STATE OF NORTH CAROLINA
DEPARTMENT OF TRANSPORTATION

October 15, 2010

Subject: **Information to comply with Section 401 conditions** for US 401 widening from SR 2044 (Ligon Mill Rd) to north of SR 2226 (Jonesville Rd), Wake County, Federal Aid No. STP-401(4), State Project No. 81403001, WBS 34506.1.1, Division 5, TIP R-2814 A.

PROJECT REFERENCE NO. R-2814A	SHEET NO. EC-24/CONST.II
R/W SHEET NO.	HYDRAULICS ENGINEER
ROADWAY DESIGN ENGINEER	
CONST. REV.	
R/W REV.

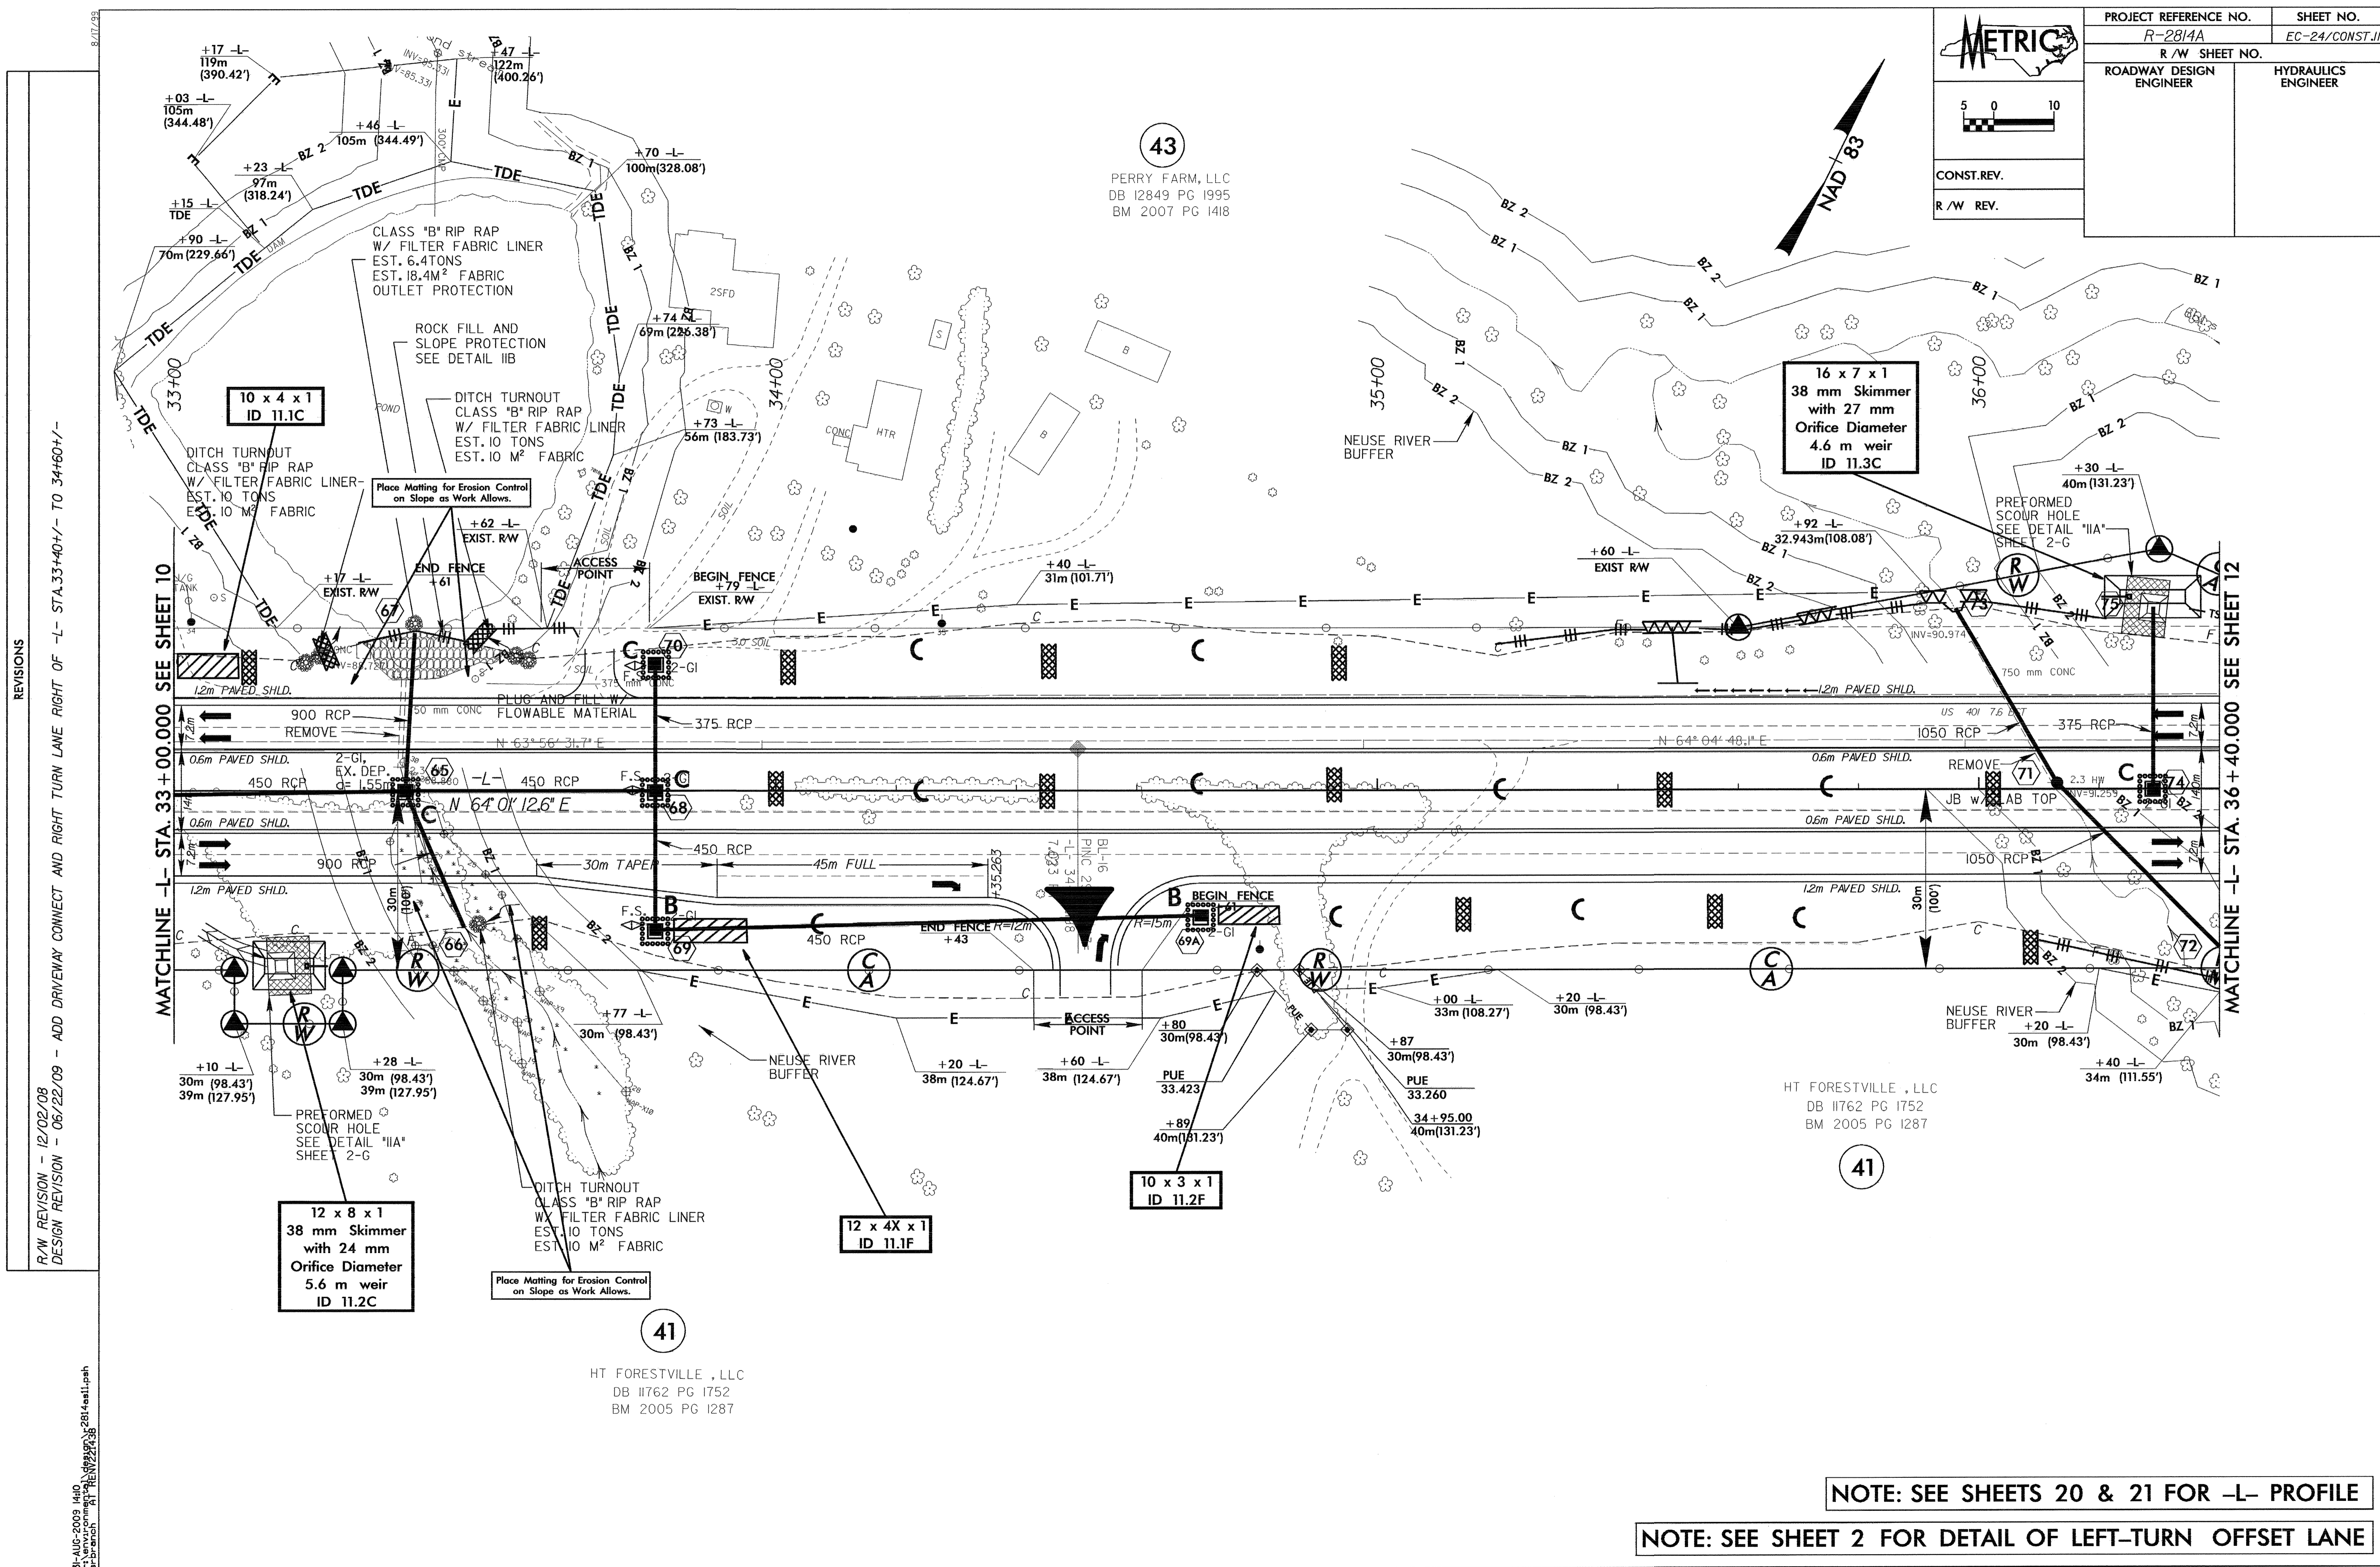
Issue: Construction plan sheet 11 and buffer permit drawing 8 depict a ditch with no liner information at the high end of a pre-formed scour hole (PFSH) located at 33+15 Rt. Stream permit drawings 12 and 13 depict rip rap in the ditch at the high end of the PFSH.

Issue: Stream permit drawings 12 and 13 depict a rip rap blob in the stream at the outlet of a 1050 mm pipe structure at 35+95 Lt. Buffer permit drawing 8 depicts no rip rap blob in the stream at the outlet of this 1050 mm pipe structure. Construction plan sheet 11 depicts a rip rap blob in the

stream at the outlet of this 1050 mm pipe structure with a note directing that outlet protection be located on banks only at this location.

Issue: A headwall has been designed to be installed at the inlet of a 900 mm pipe structure at Station 33+45 Rt.

Response: Revised construction plan sheet 11 and revised buffer permit drawing 8 reflect rip rap in the ditch at the high end of the PFSH as depicted on stream permit drawings 12 and 13.

Response: This construction revision has been depicted on revised construction plan 11, revised stream permit drawings 12 and 13, and revised buffer permit drawing 8.
